Subject: WA/63/21/PL

Drawing Title:
PROPOSED ALTERNATIVE ACCESS

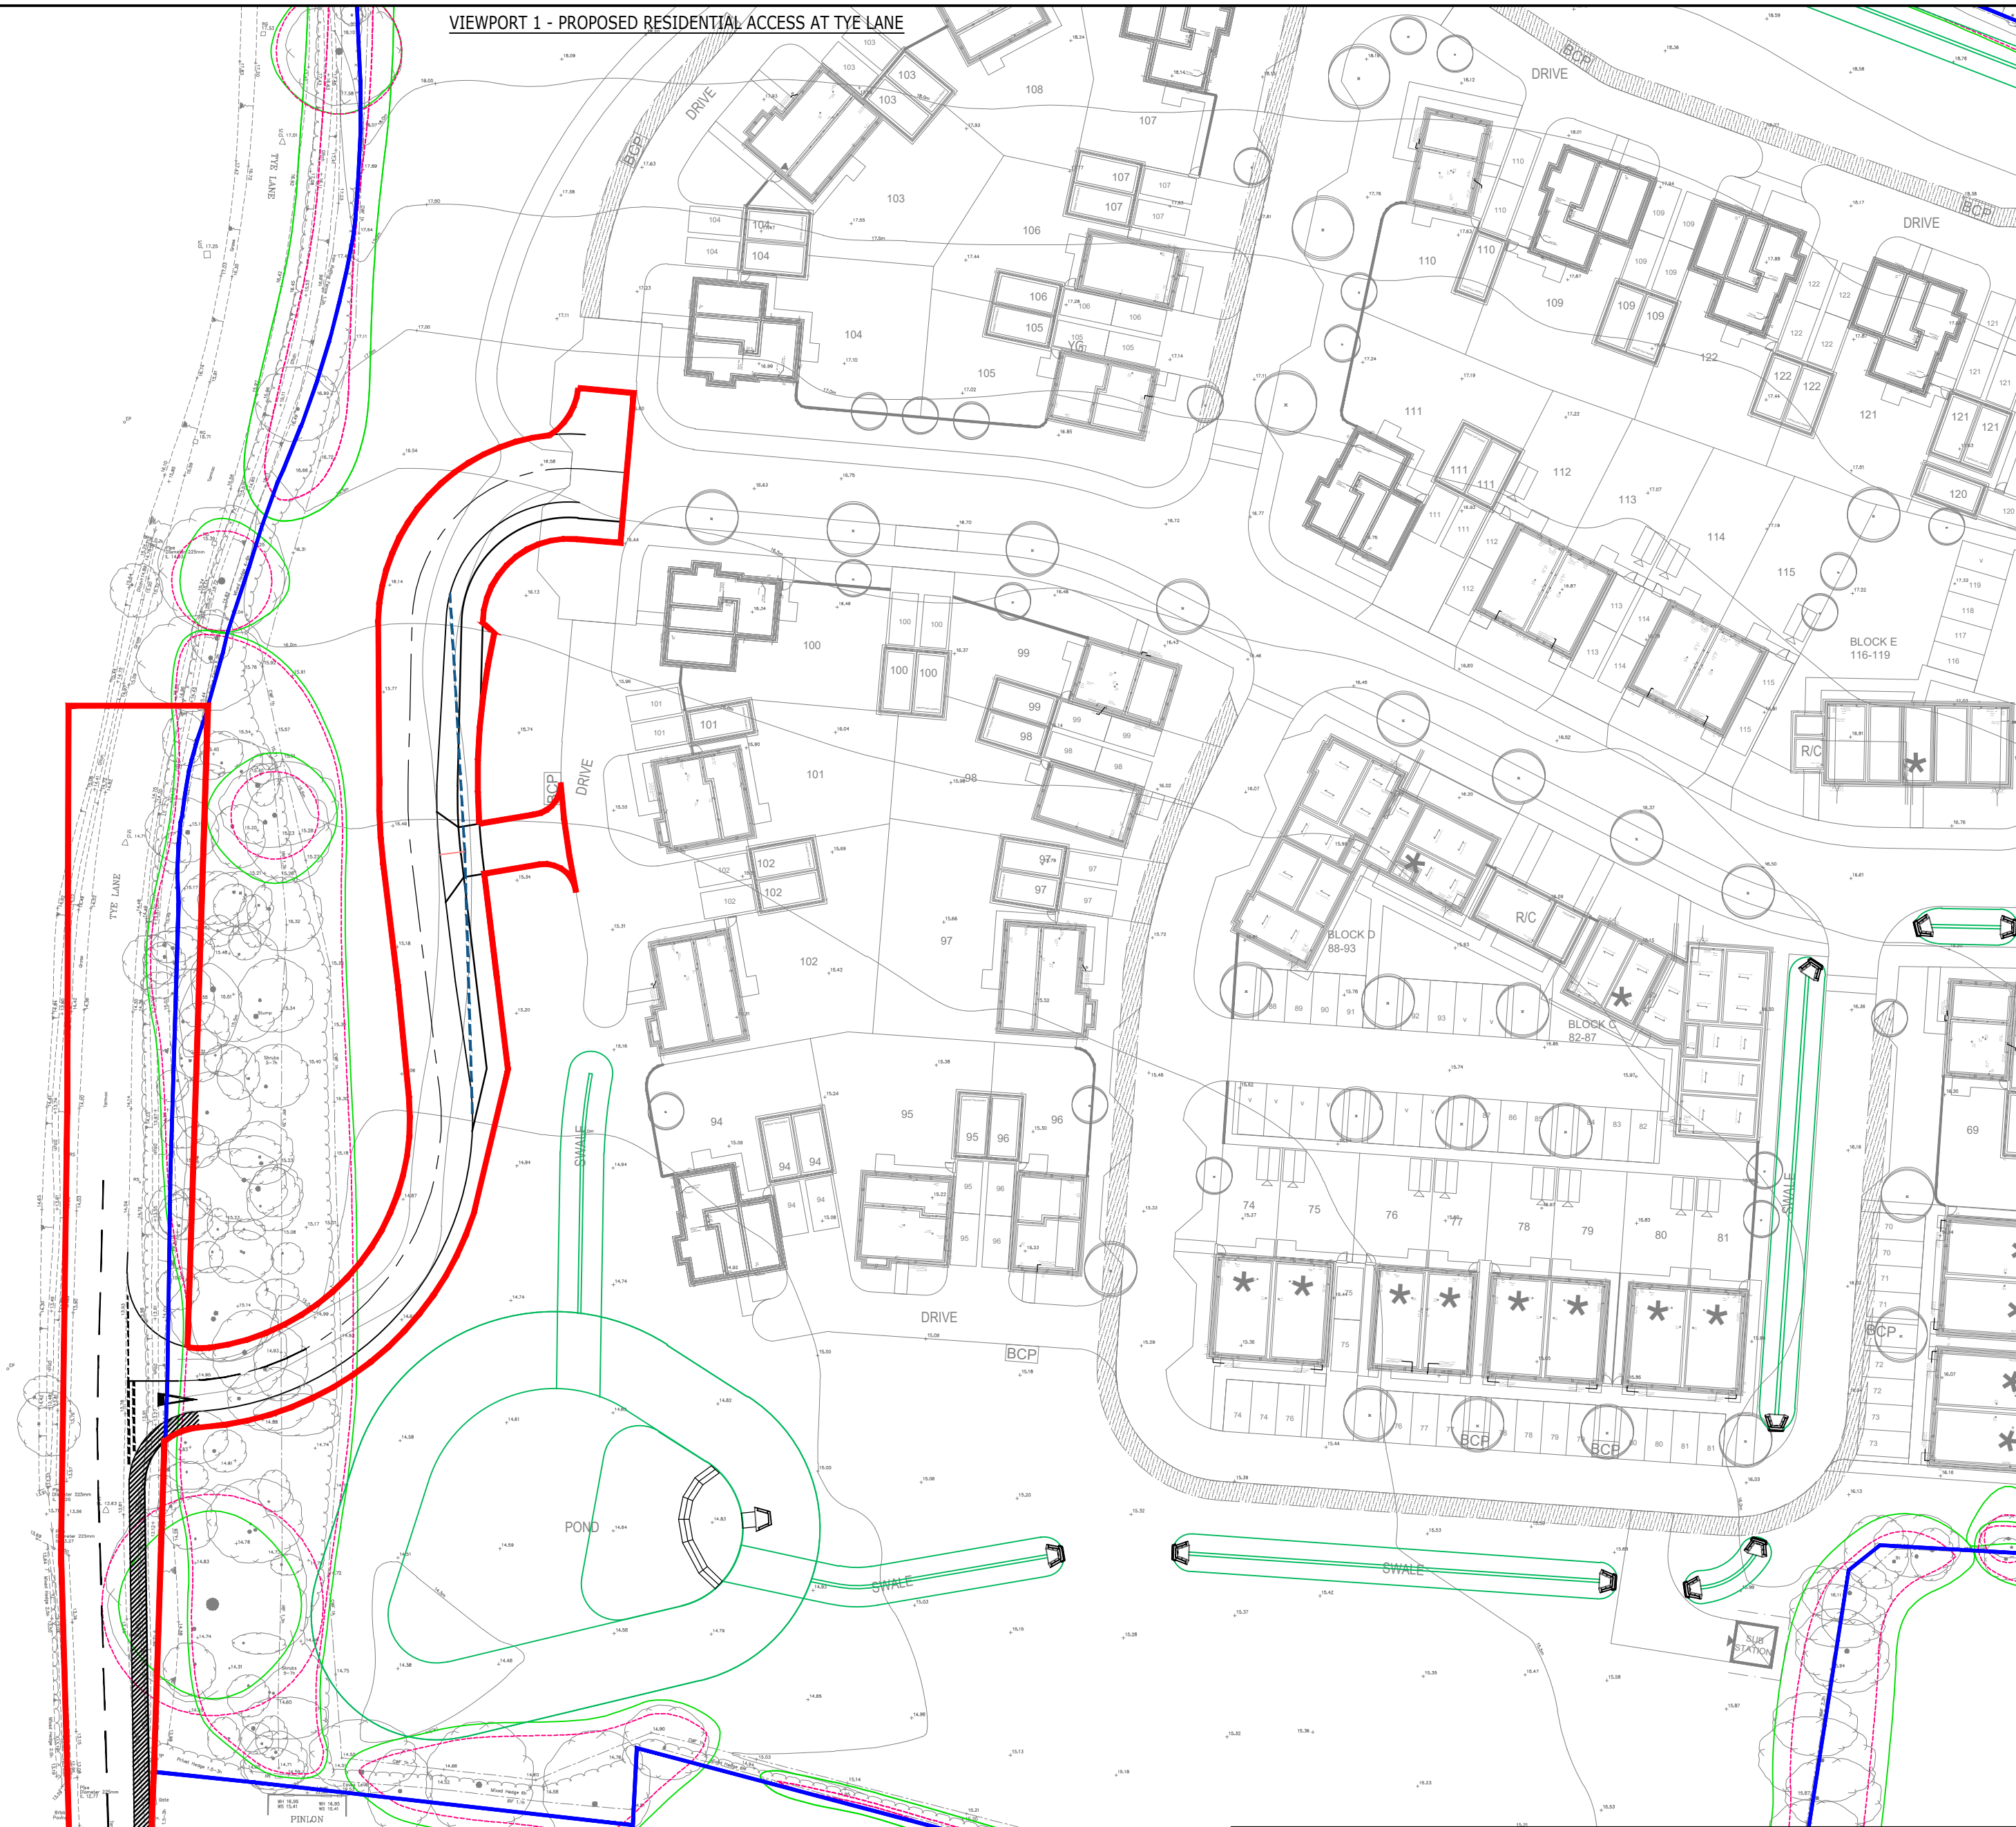
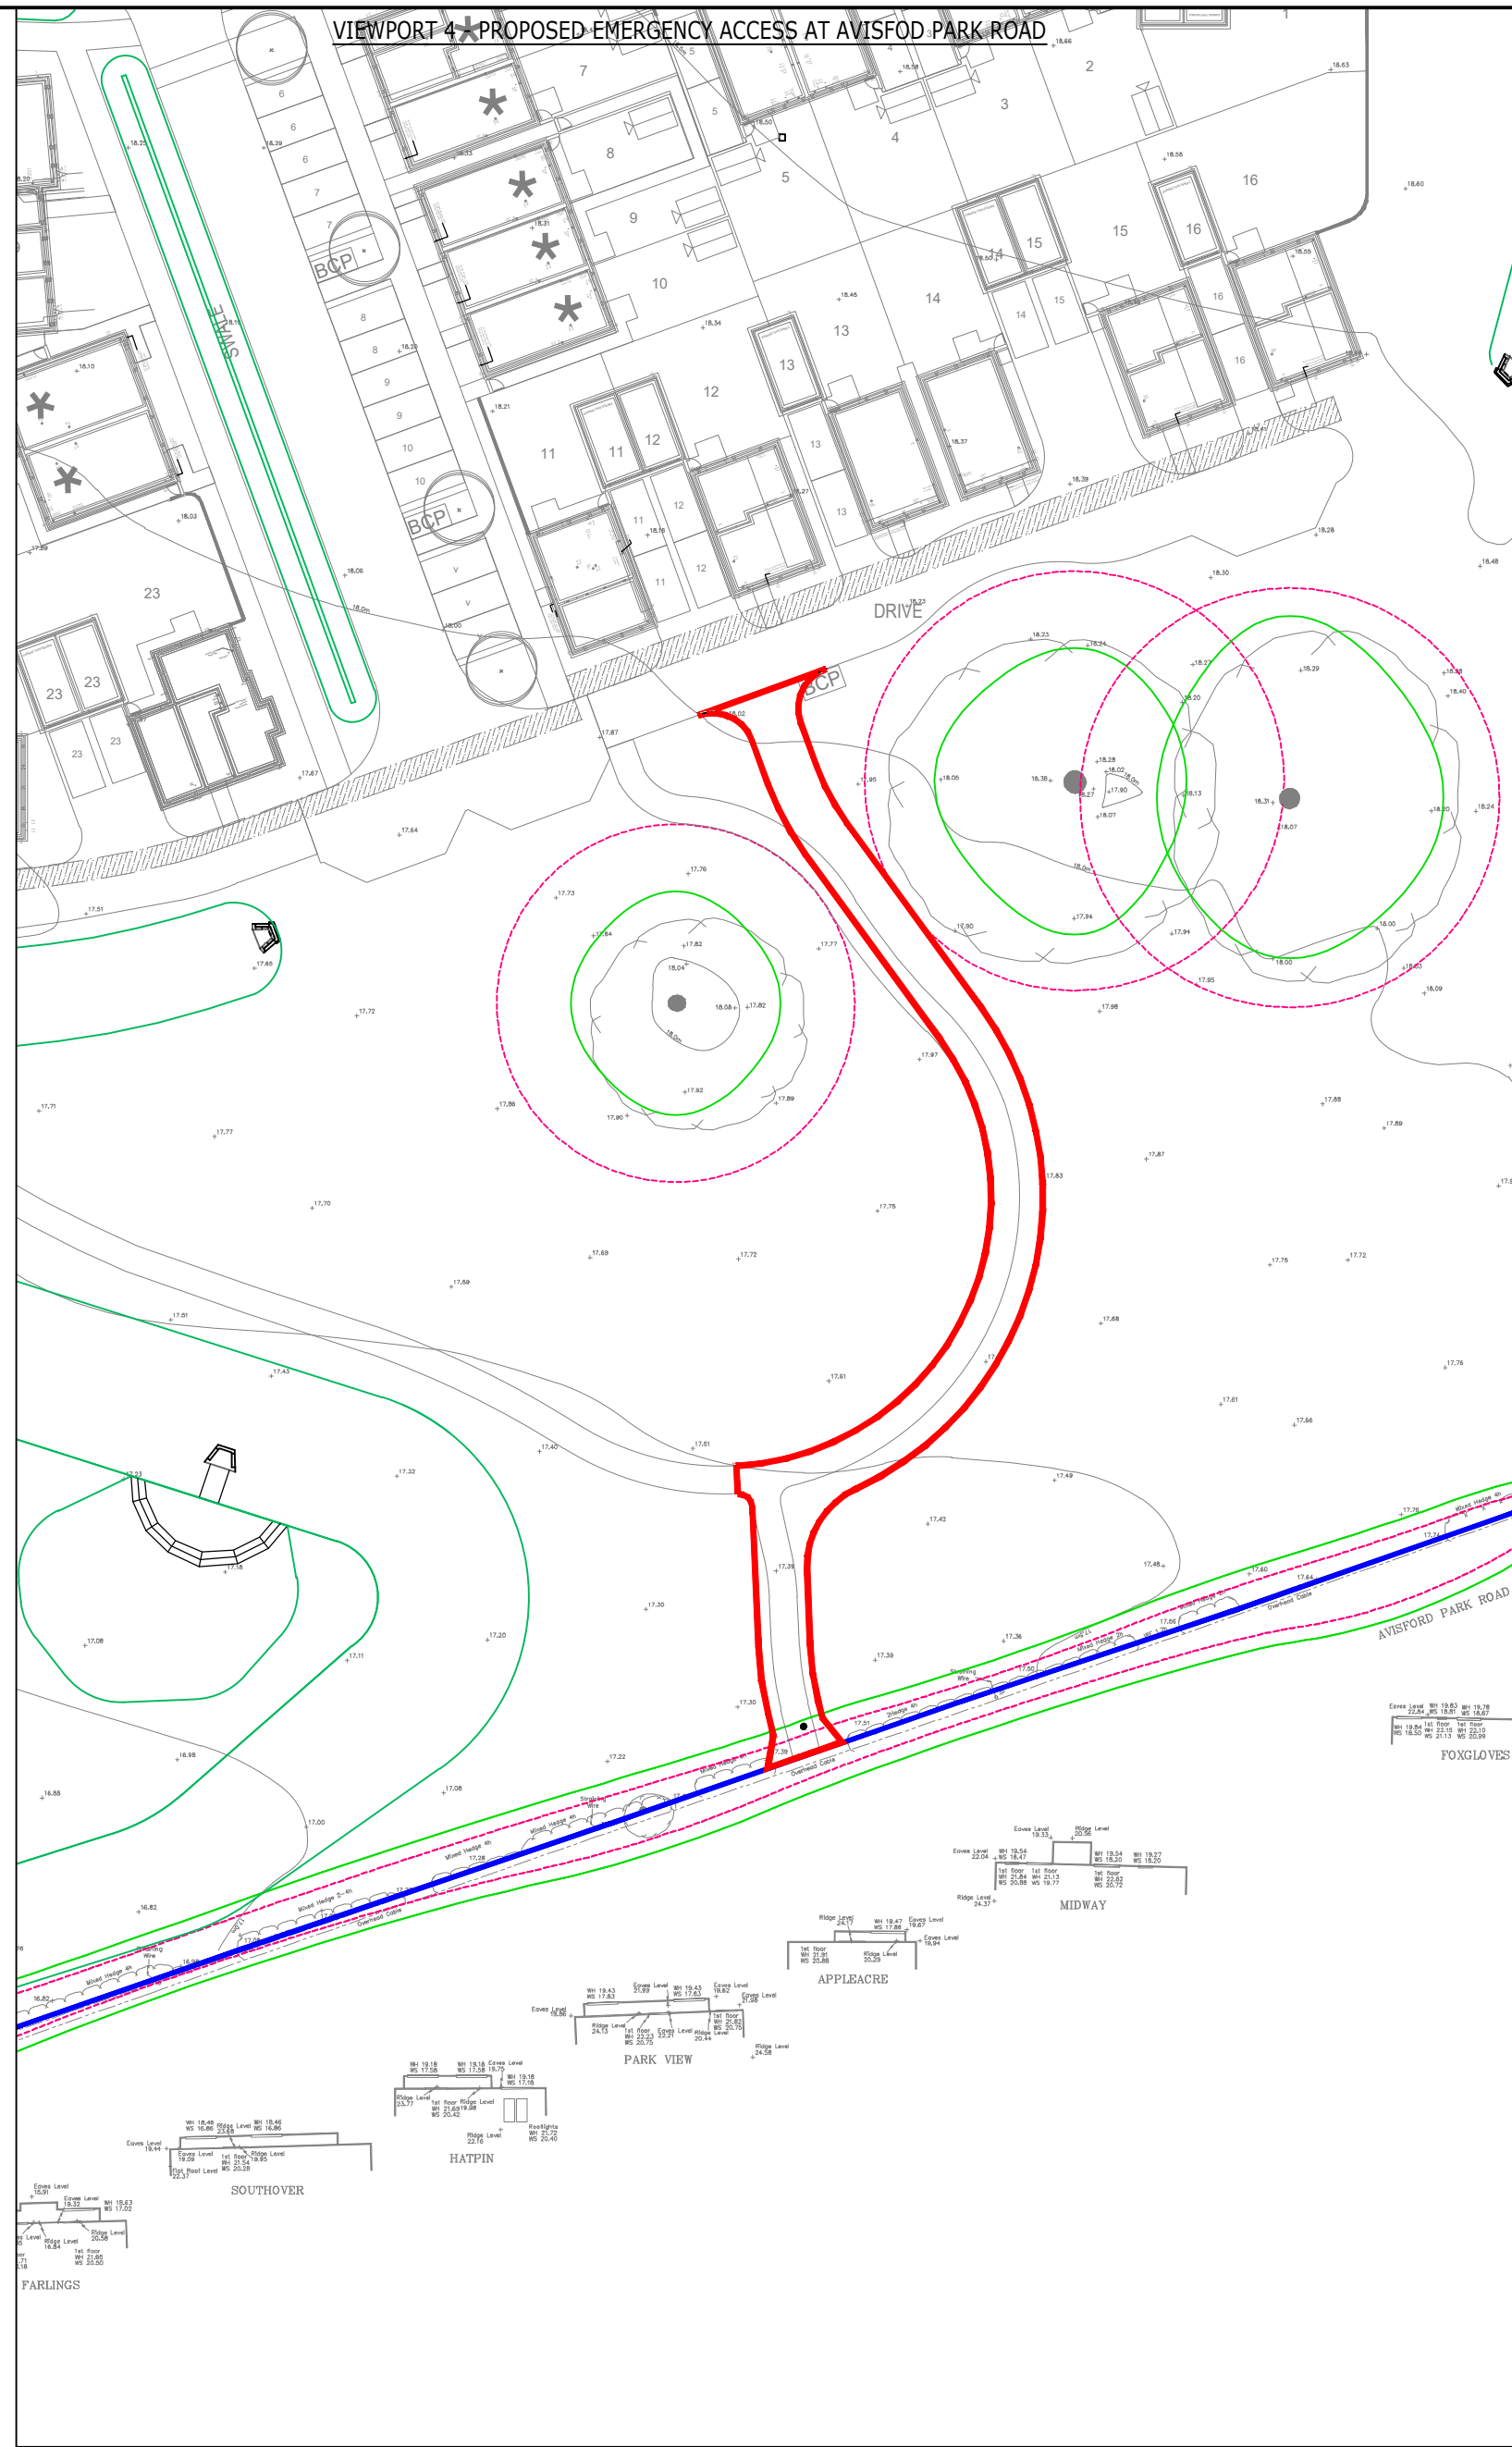
Tye Lane is totally unsuitable for the vehicle access which is being proposed and has been recognised as such by Arun District Council in the refusal of past access applications. The Lane is too narrow to allow safe two way traffic and if passed will substantially increase the danger to pedestrians, cyclists and other non motorised units. It should be noted that this application is very premature as the final route of the A27 has not been decided and has been pointed out by others may never happen.
